PORTLAND MAINE

December 31, 2009

Re: 34 Dow Street – 055 E001 – B-1/R-6 – expansion of entry porch – permit #09-1445

INSPECTION OF PREMISES

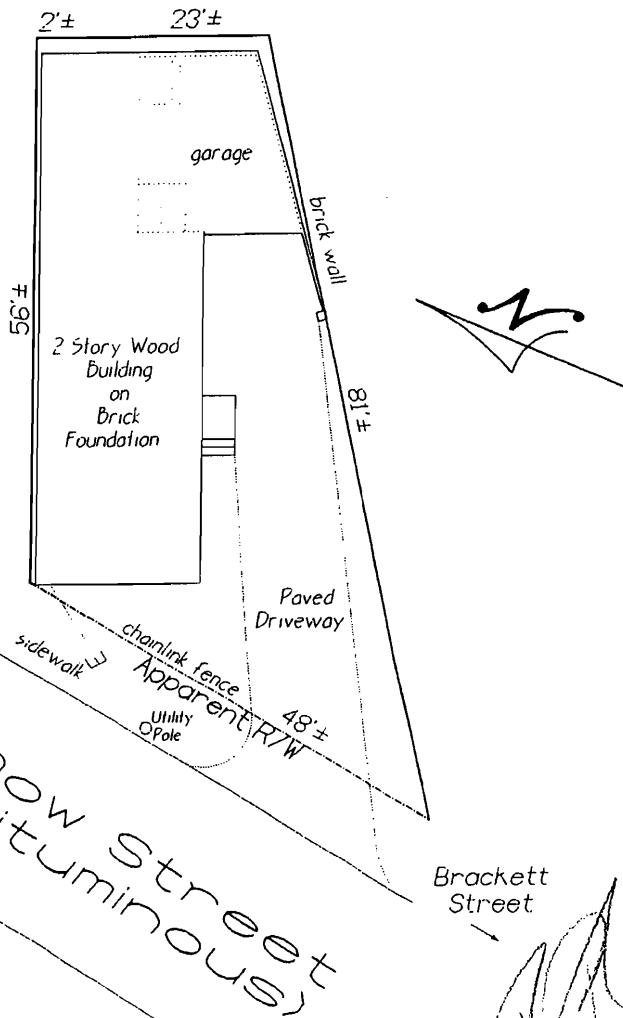
I have reviewed your application to enlarge the entry porch. Your property is in the R-6 residential zone. For a single family home in the R-6 zone, you are allowed to cover 50% of the lot with the footprint of structures [section 14-139(1)(e)]. 50% of the lot (2,031 s.f.) is 1015.5 square feet. The footprint of the existing structures on the property is 1125.8 square feet, so it is already nonconforming. You cannot make the property more nonconforming by increasing the size of the existing entry, so I must deny your application to expand your entry porch.

EXT. STAIR DETAIL
SCALE: 1" = 1'-0"

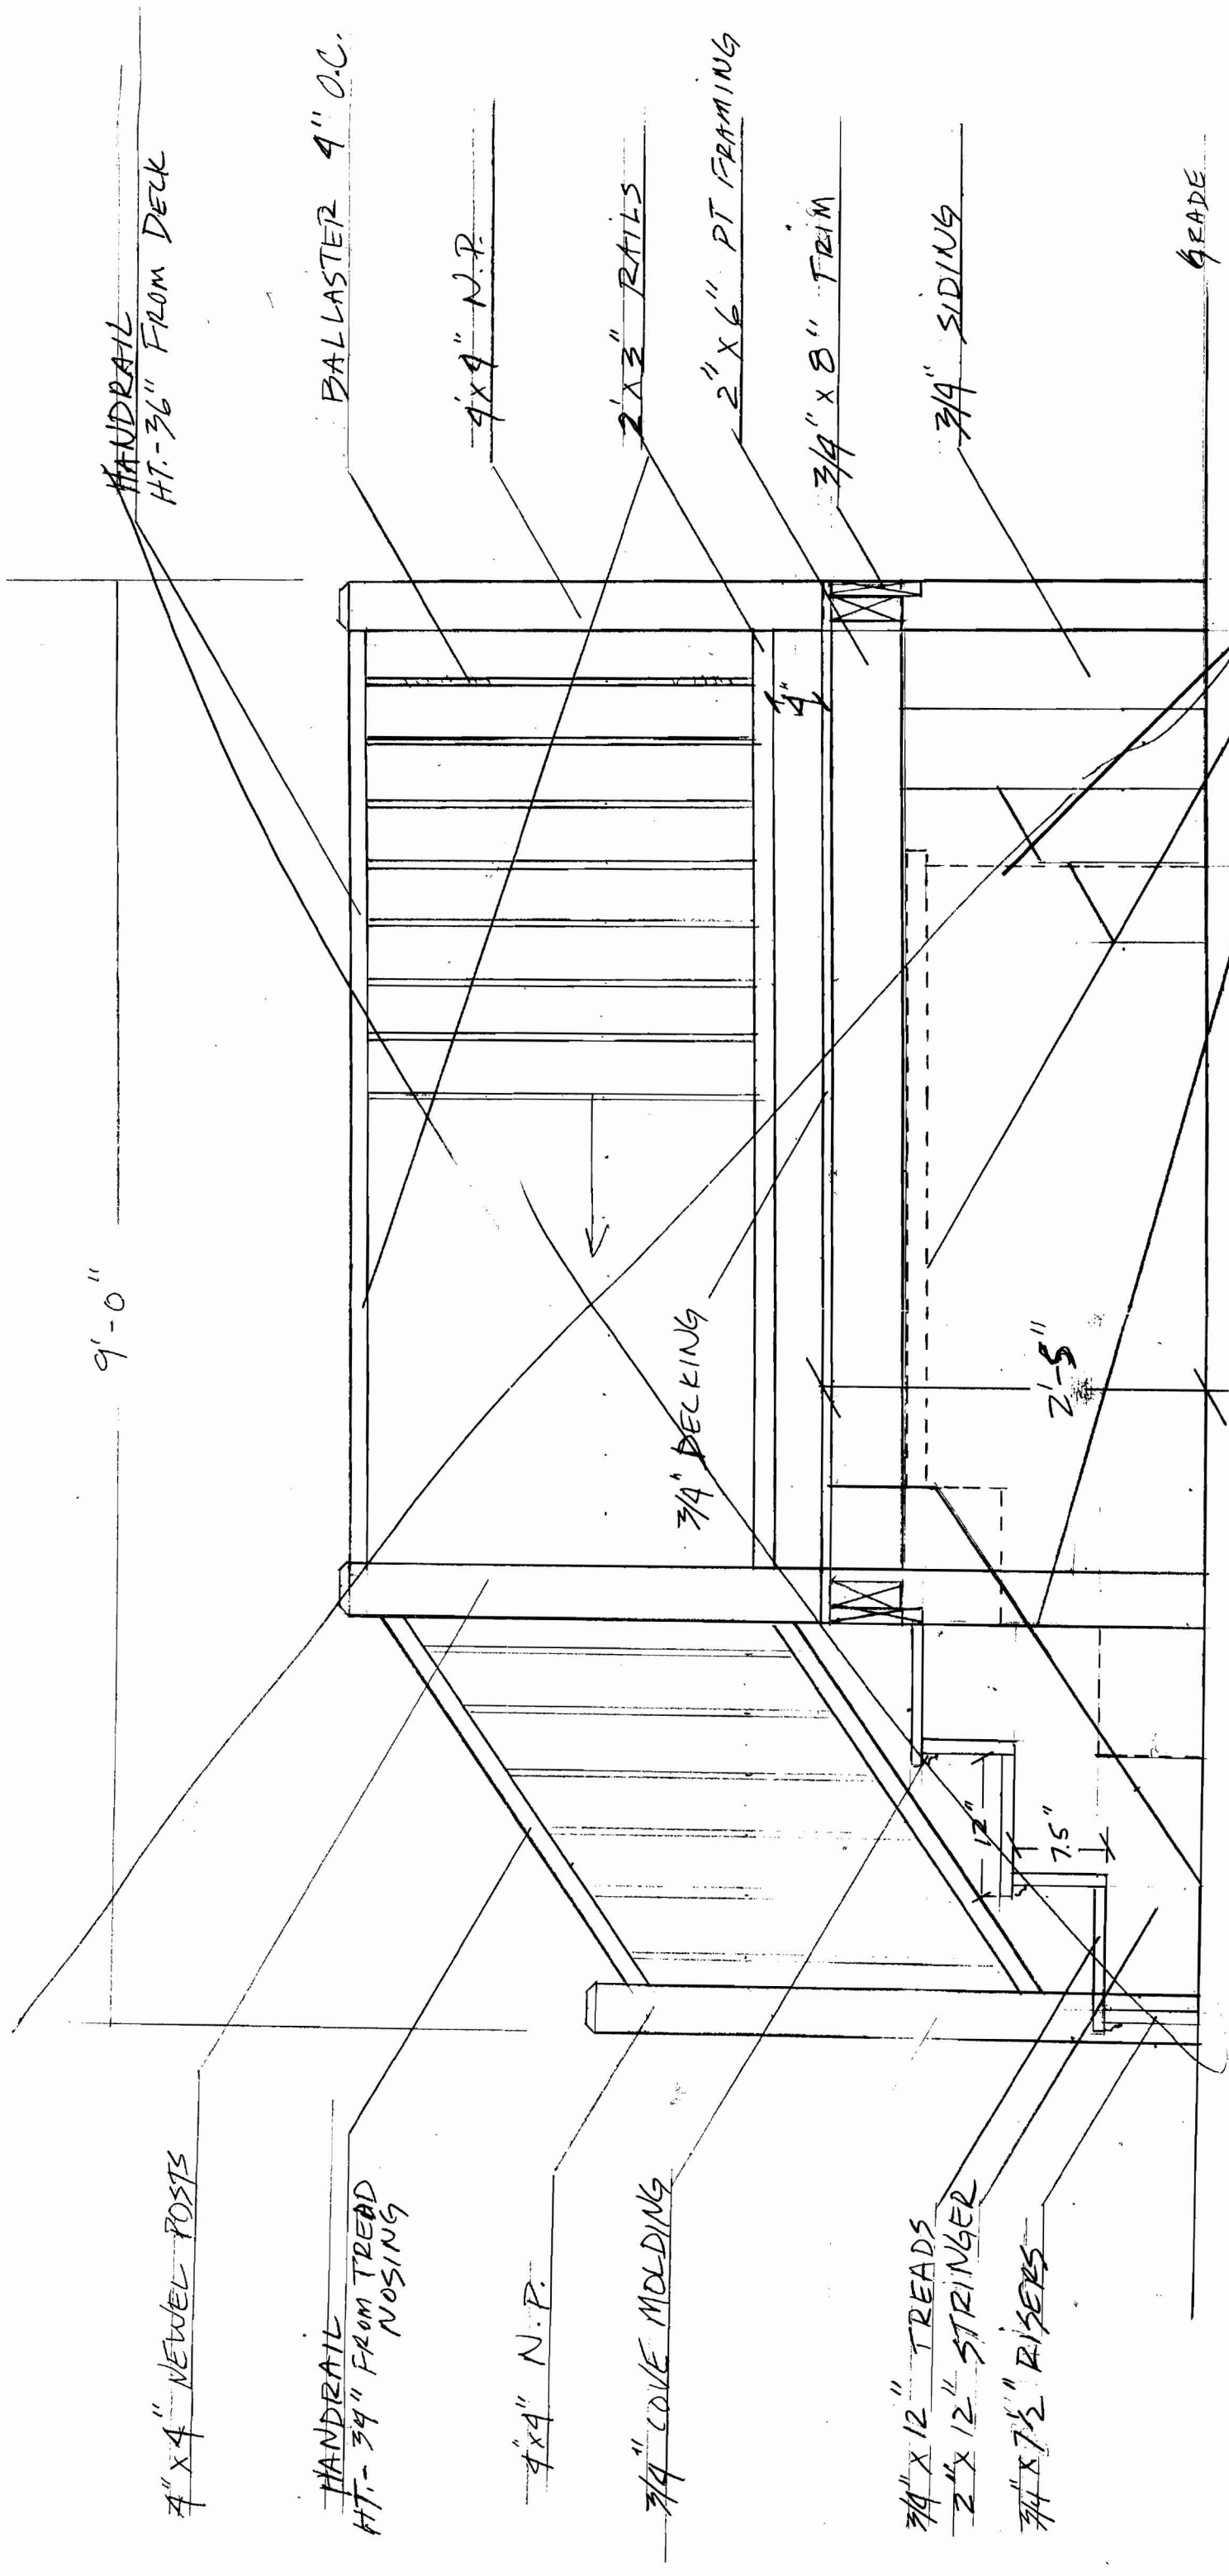
If you choose not to file an appeal, you must revise your application to rebuild the entry within the existing footprint. Your permit is on hold until you either go through the appeal process or submit a revision.
